RE: Lot 18A Block 2 Unit 19 Volcano Cliffs Subd.

7700 Compass Dr. NW

Request for Permanent C.O. - Accepted

**Engineers Stamp Date 10/26/15 (D10D003G18A)**

PREPARED BY STEVEN J. METRO, PE AND PS  
**GRADING & DRAINAGE PLAN**  
7700 Compass Drive NW  
LOT 18A, BLOCK 2, UNIT 19 VCS

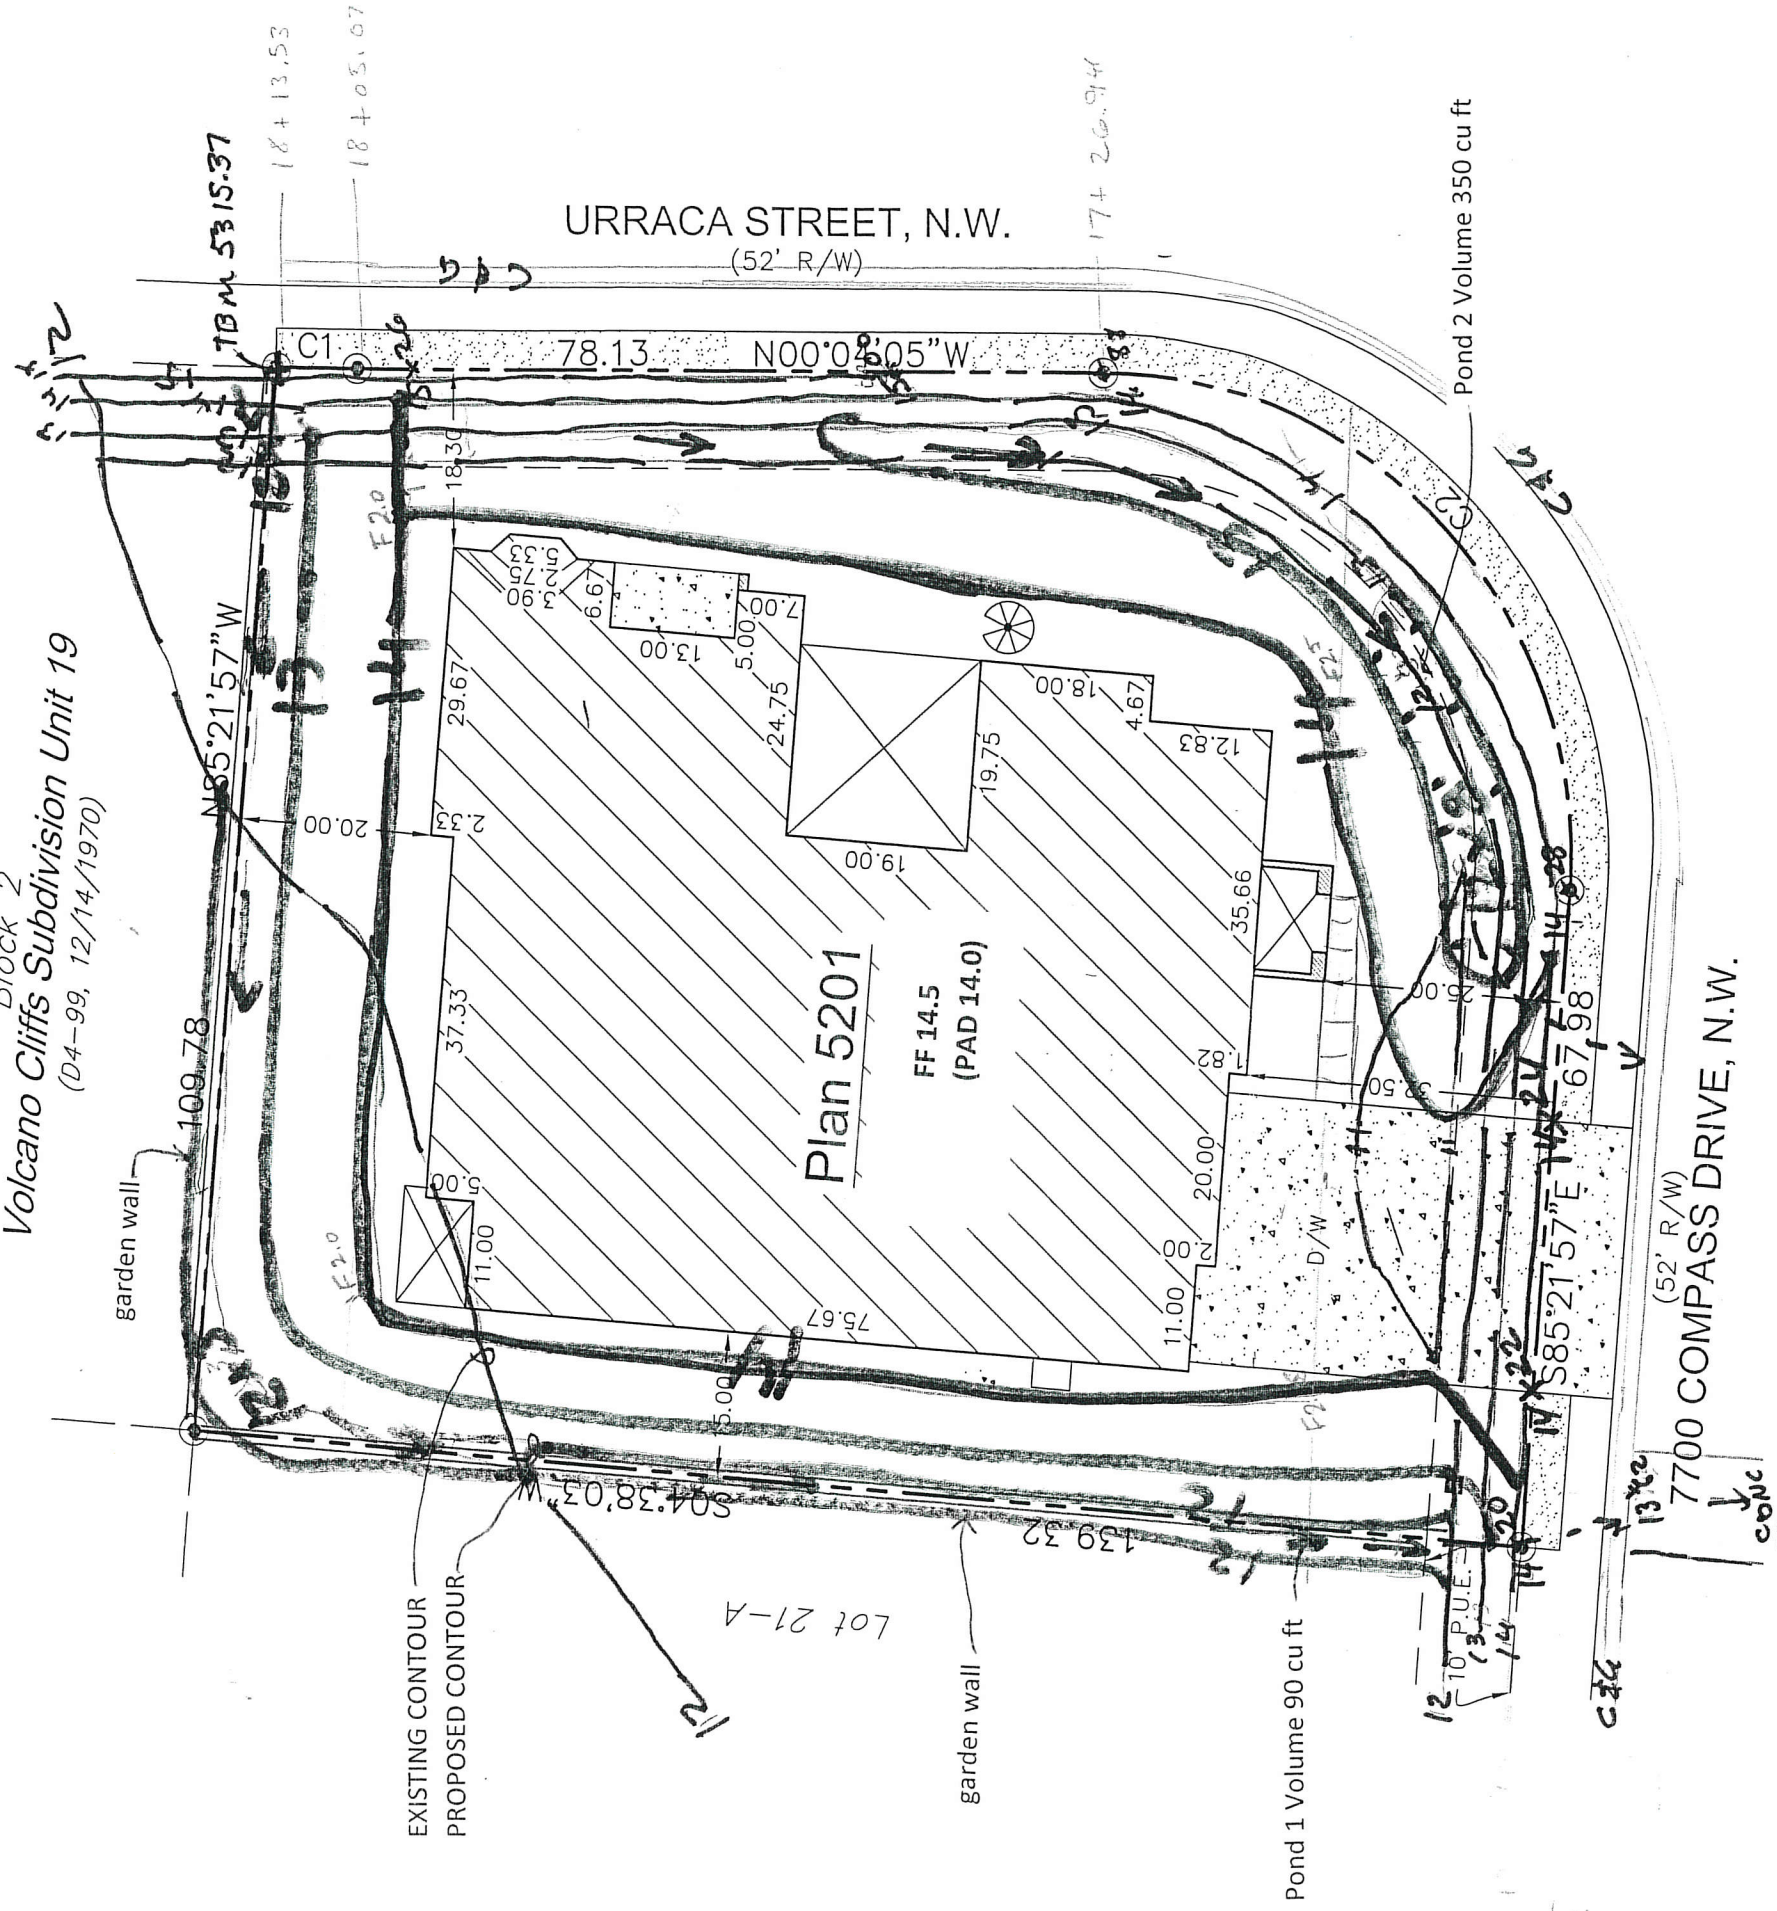
Based on the Certification received 11/7/2016, the above mentioned residence is acceptable for release of Certificate of Occupancy by Hydrology. The pond in the backyard was designed to be further away from the residence. Recommend moving the pond further to the SW corner as indicated on the approved grading and drainage plan.
